Re: Mesa del Sol Montage Unit 4 (Project # PR-2020-003422, Application # SD-2020-00091,  
Hydrology File R16D006A), Comment Response Letter

Enclosed are the responses to the comments provided on the June 17, 2020 DRB hearing.  
Comments and responses are listed below by department.

### Hydrology Section Comments

Residual Flow = 32.19 - 2*(6.6) = 18.99cfs

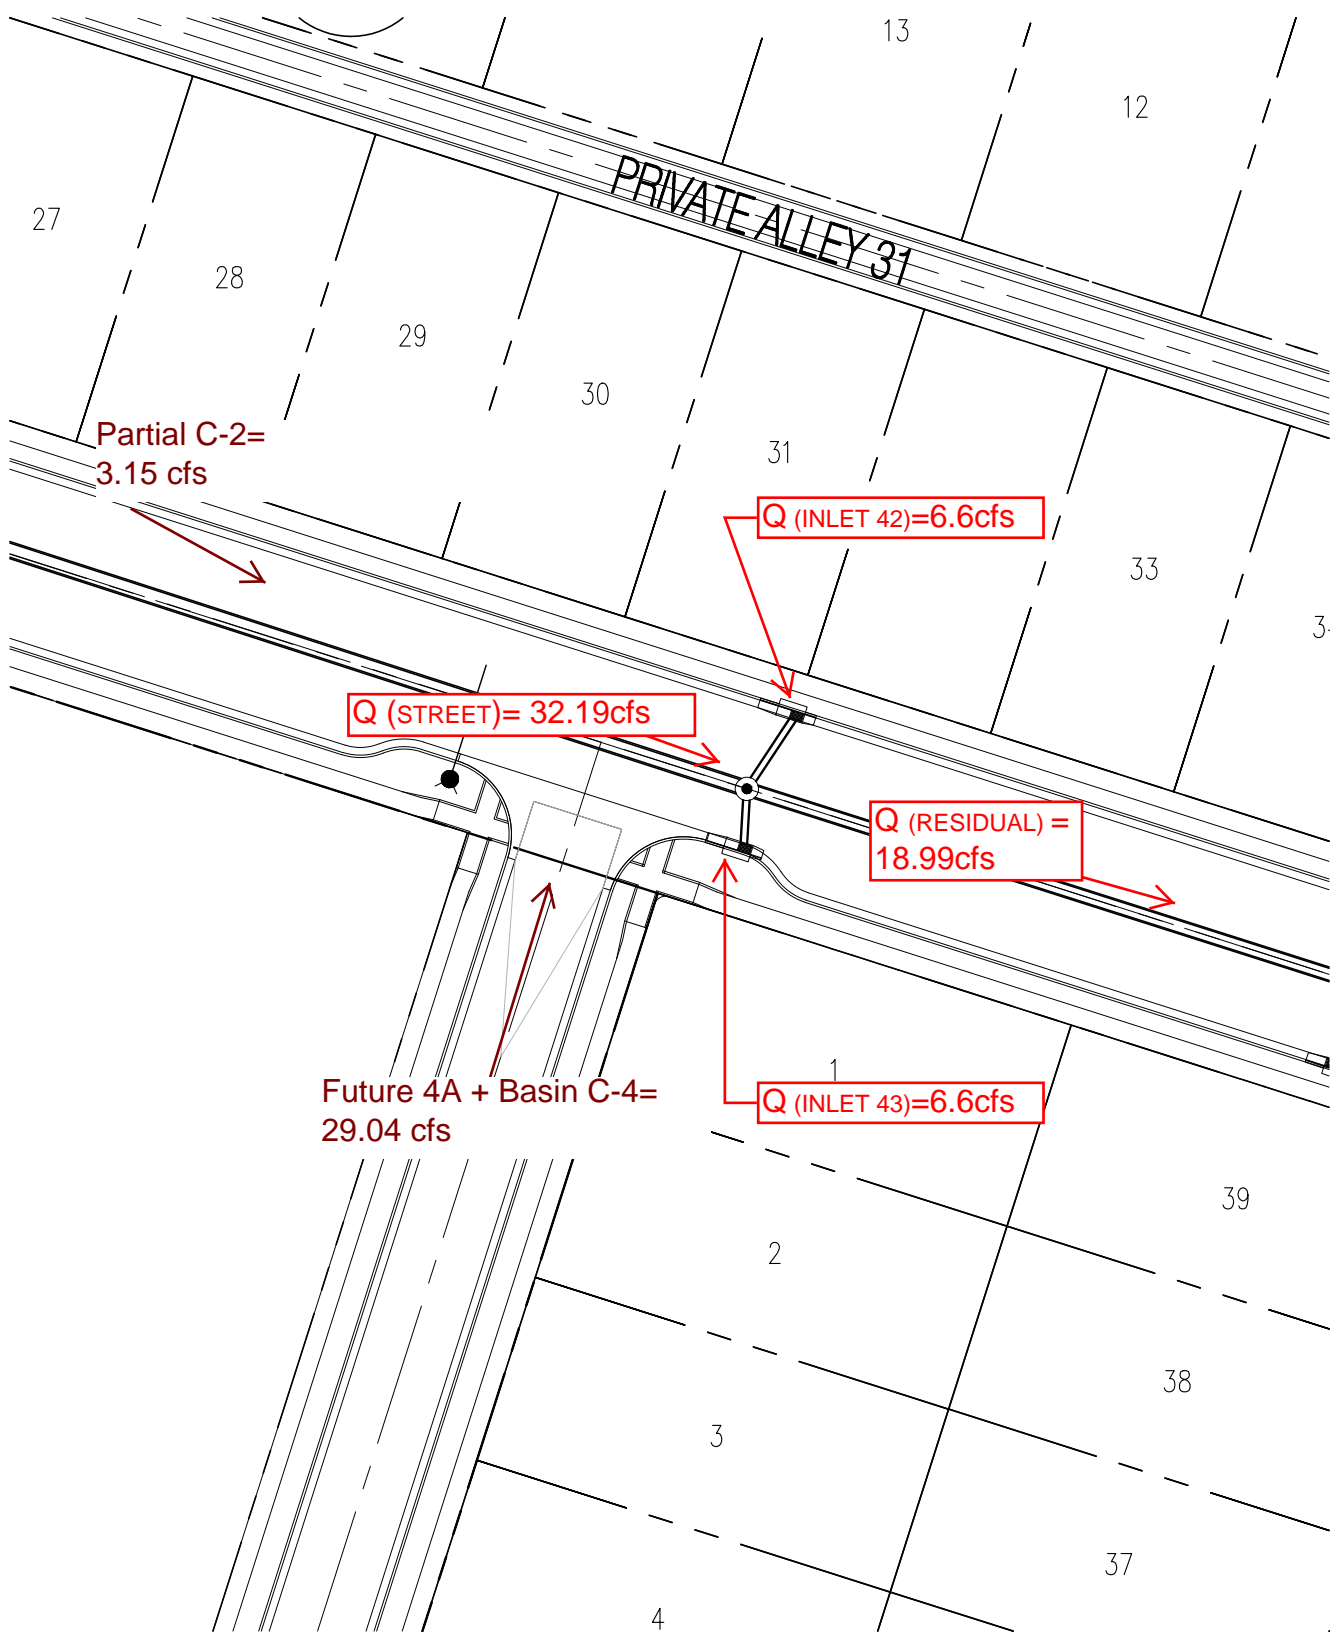
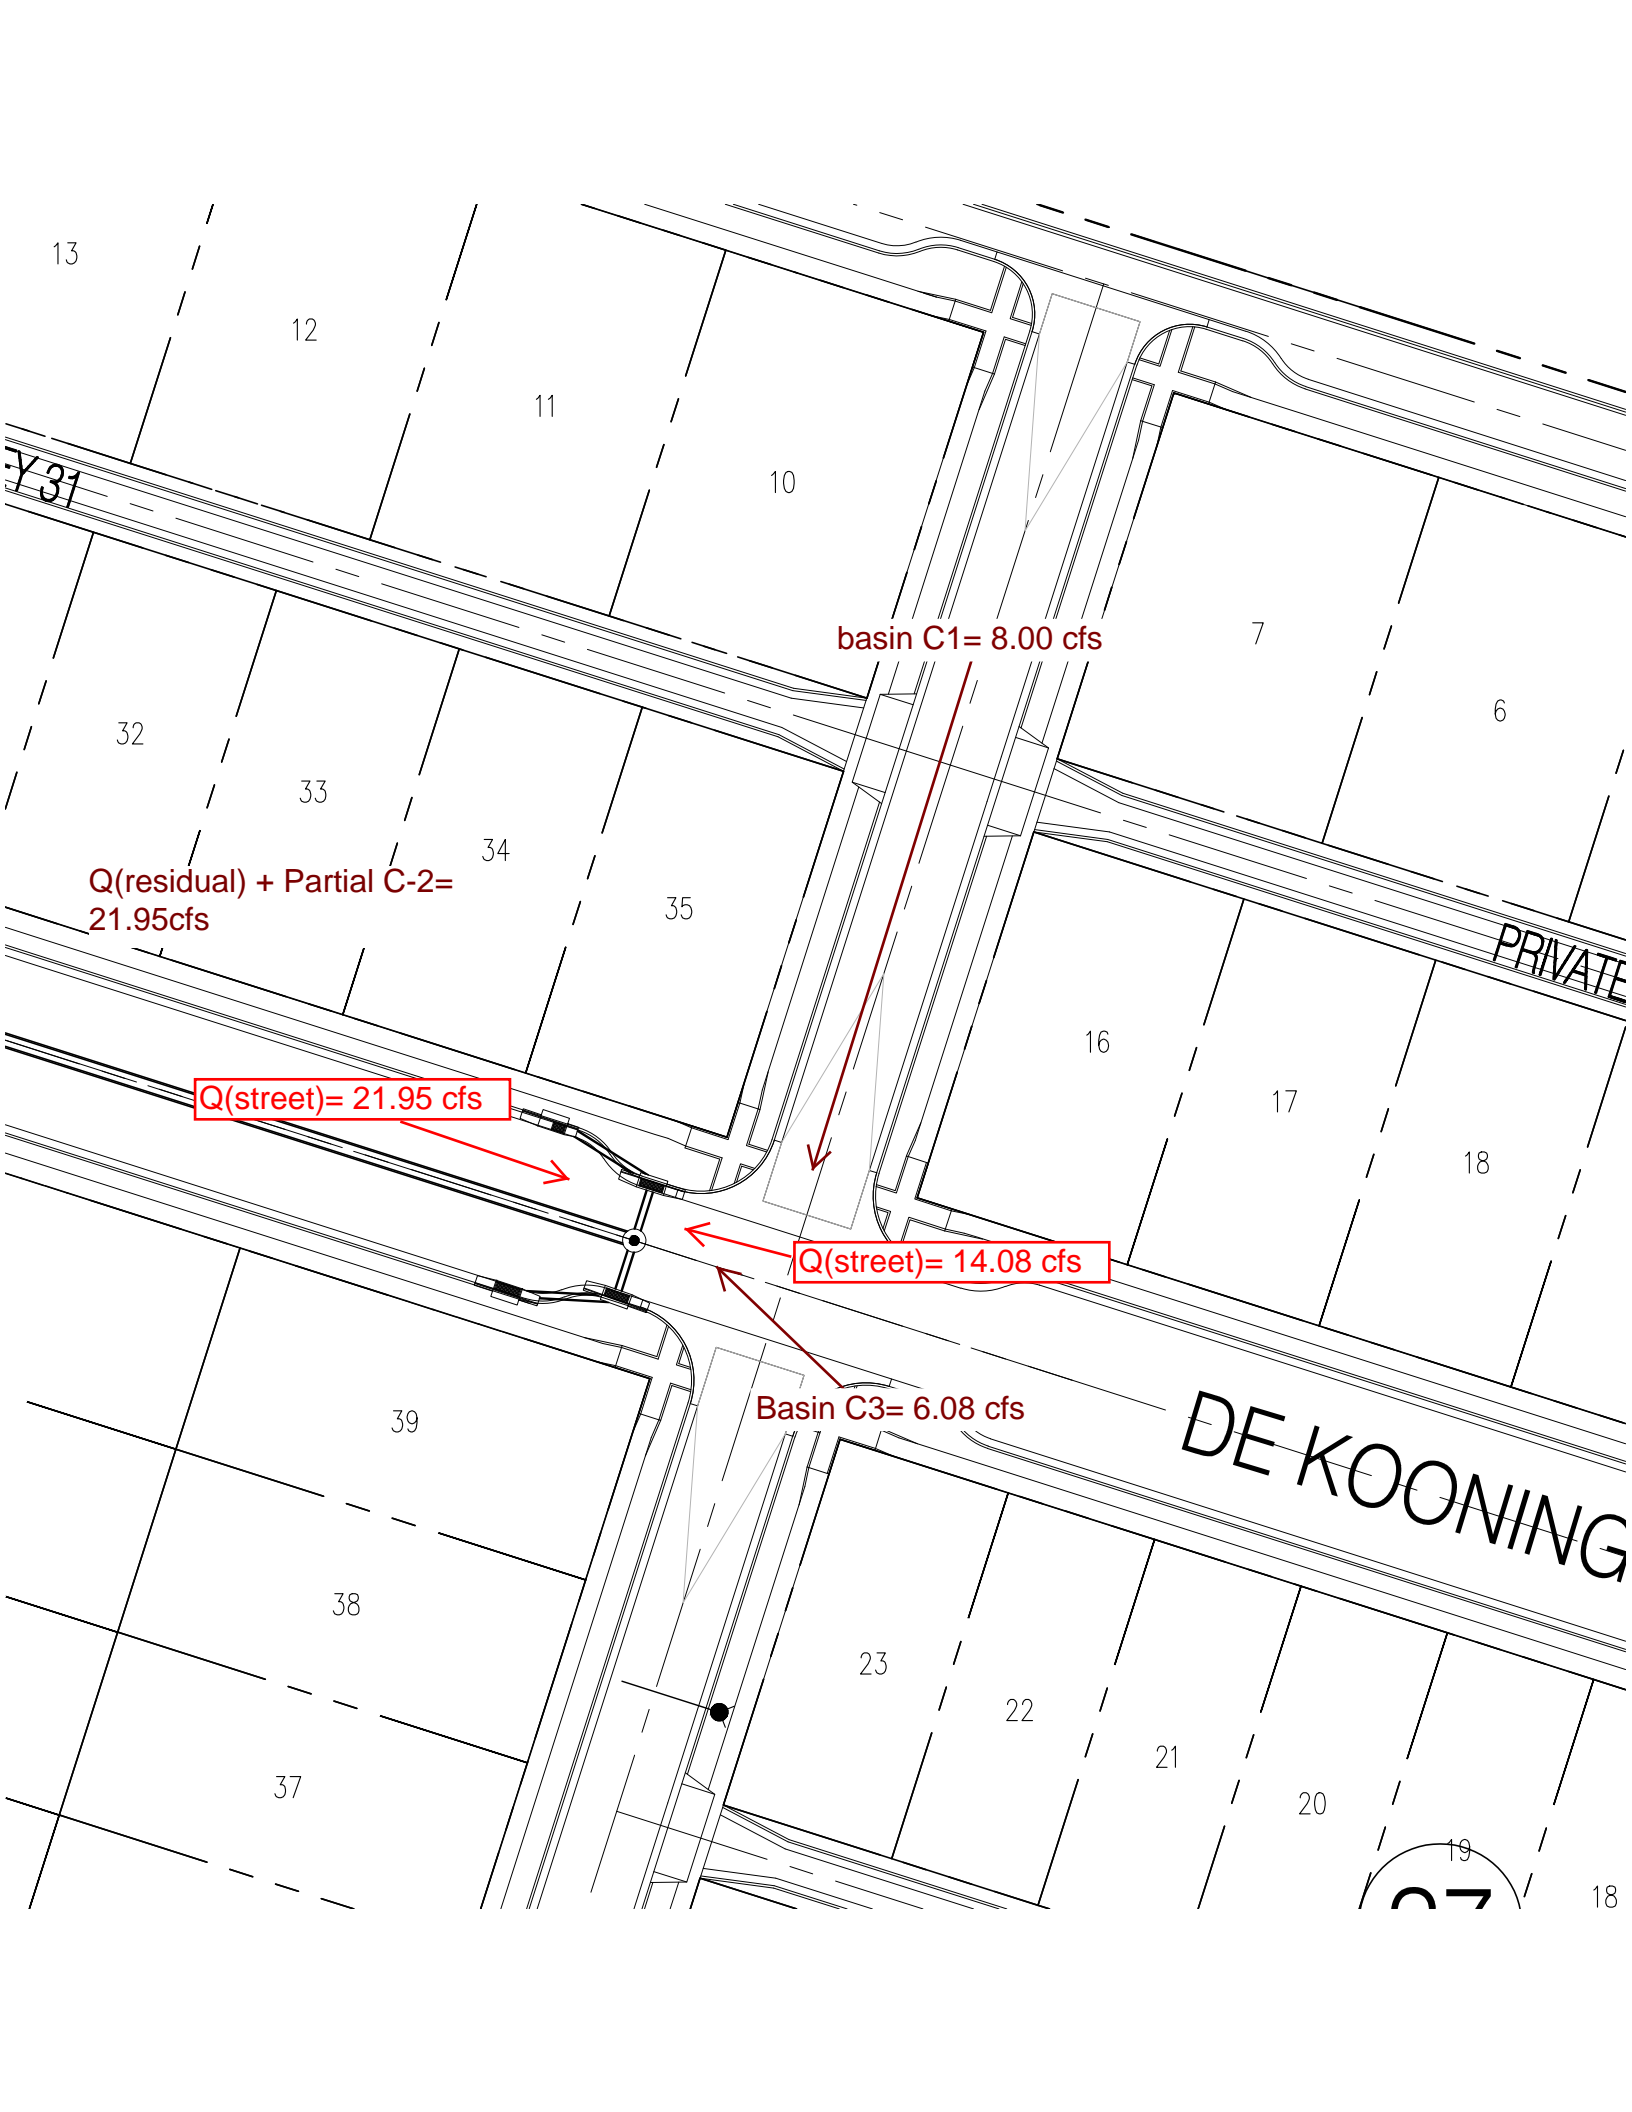
1. An approved grading plan and drainage report is required.  
*Response: A revised grading and drainage is submitted concurrently to this submittal.*
2. In the Amended Drainage Report on pages 30,32 and 36 for inlets on Dekooning and Sagan, please size/type of inlet being analyzed. All previous sections listed this information,  
*Response: Completed. See attached Revised Drainage Report*
